Judge Orr Ranchettes, SF-17-021

Please accept the following comments from El Paso County Public Health (EPCPH) regarding the 40.67 acre, 7 residential lot development project referenced above:

## PRELIMINARY PLAN

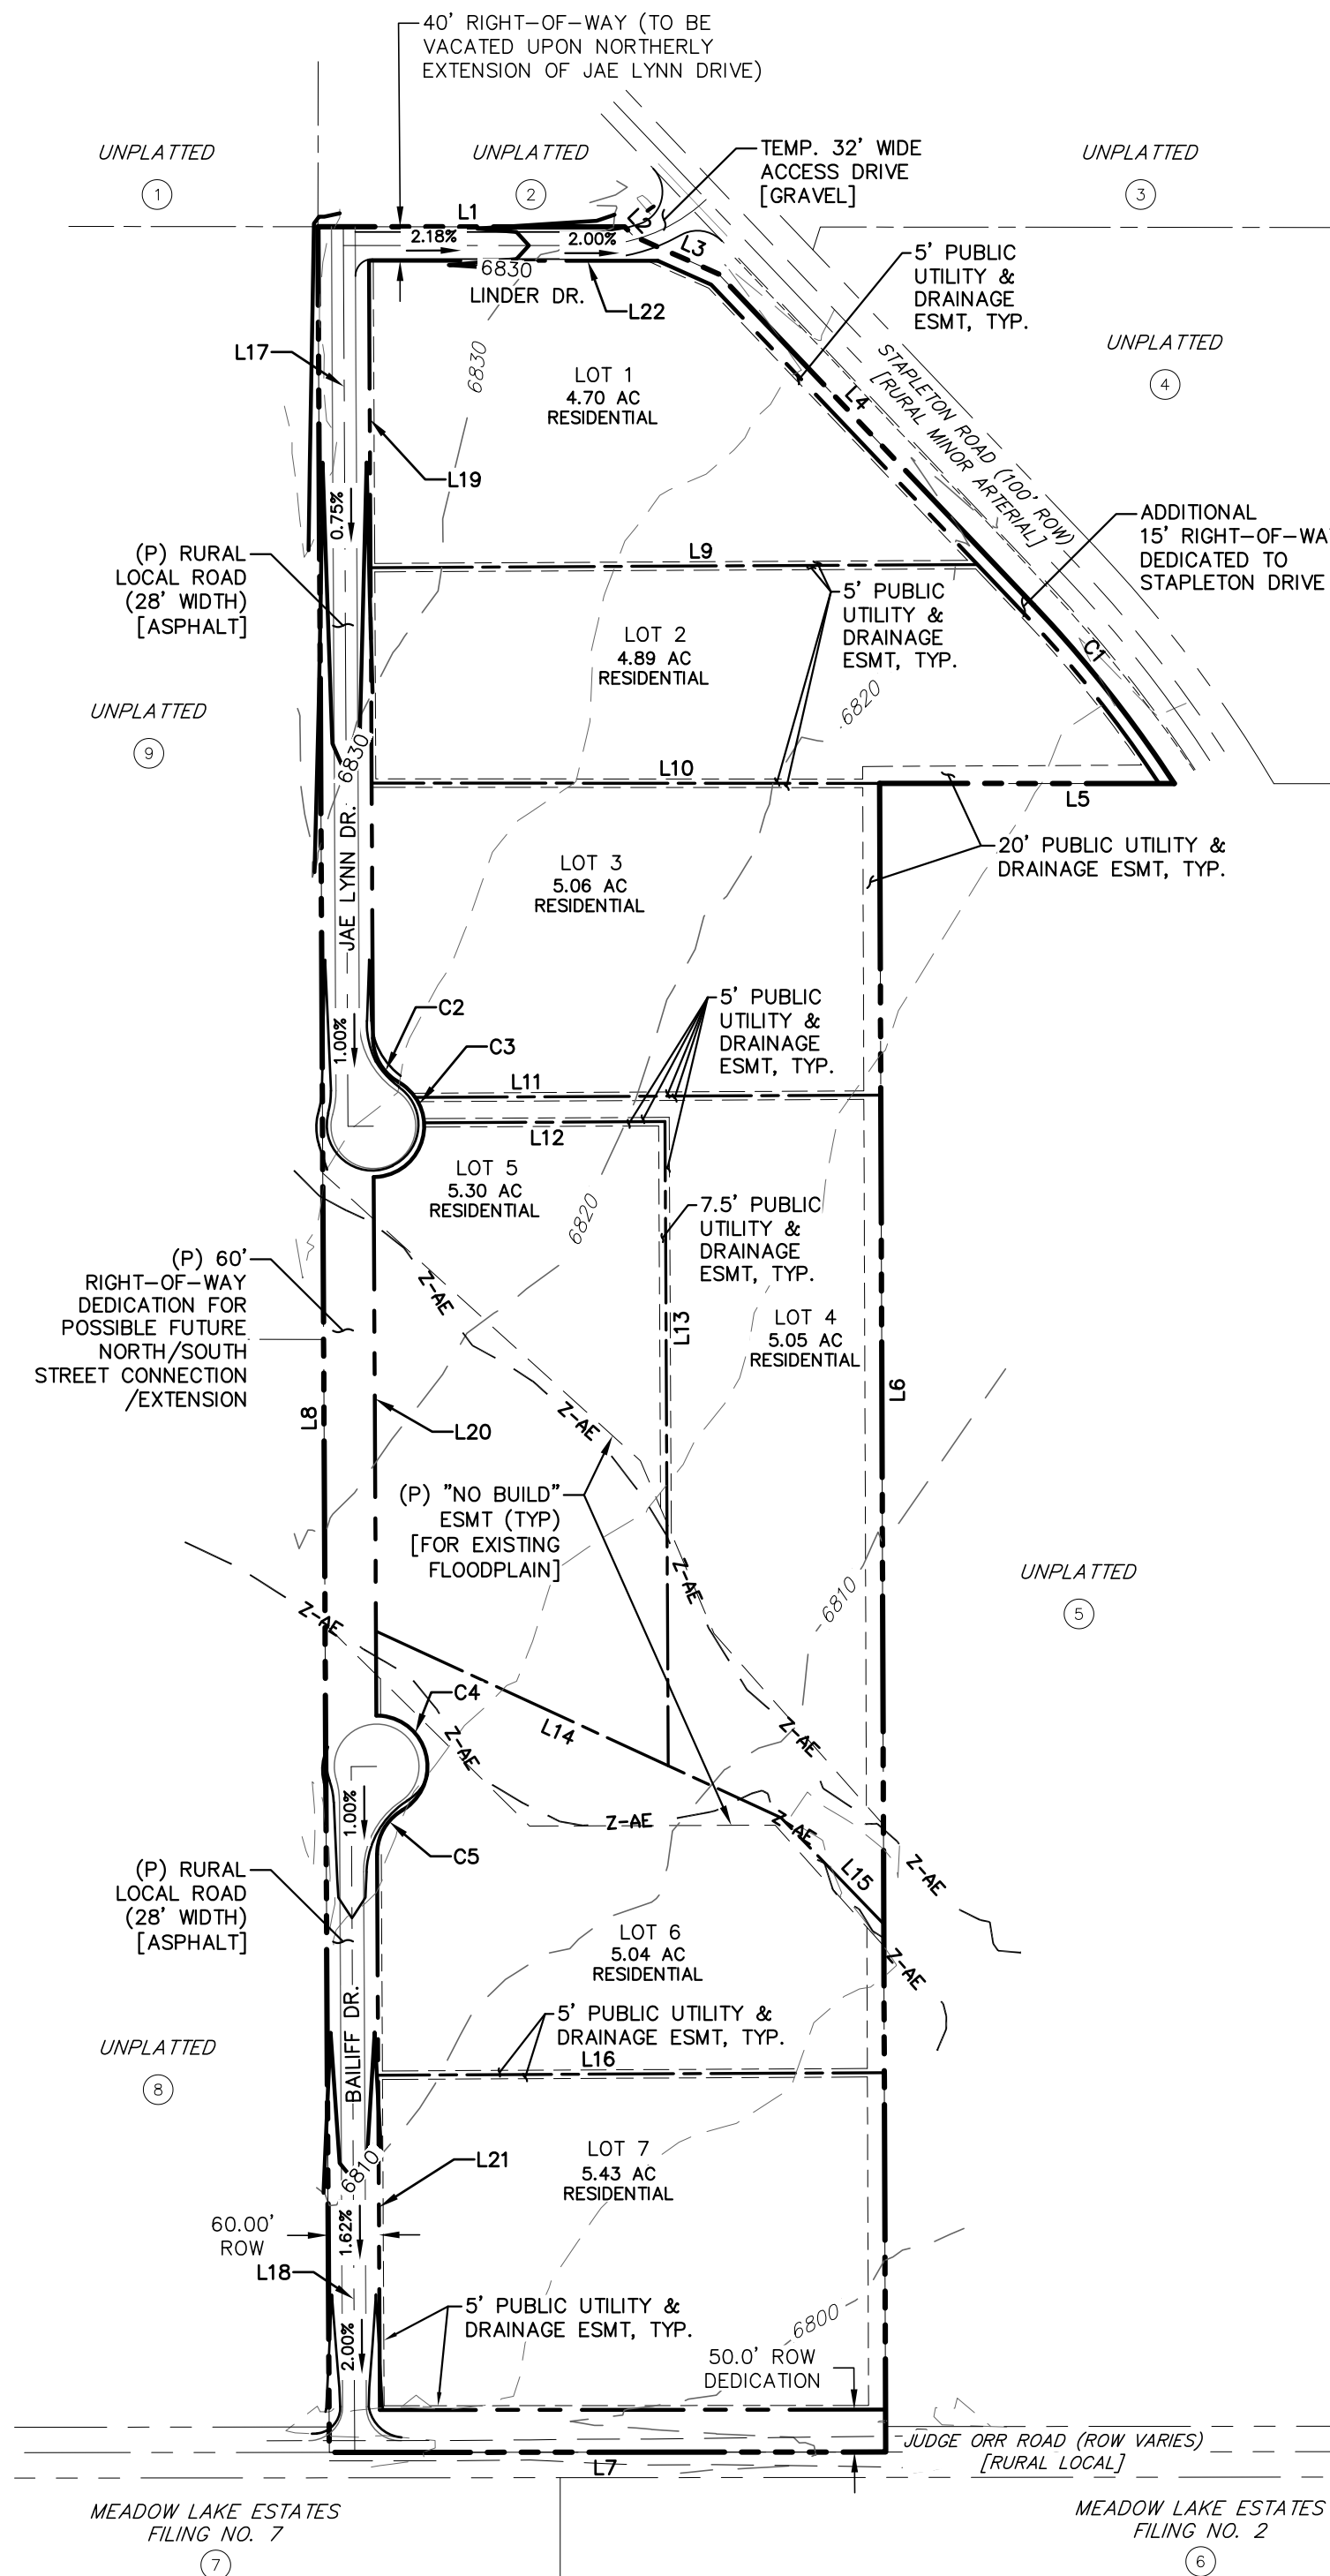
- **Careful planning is required when locating private wells and OWTS's on lots 5 and 4 because of the flood plain (no-build area) impact on lot 5 and the narrow shape of adjoining lot 4.**
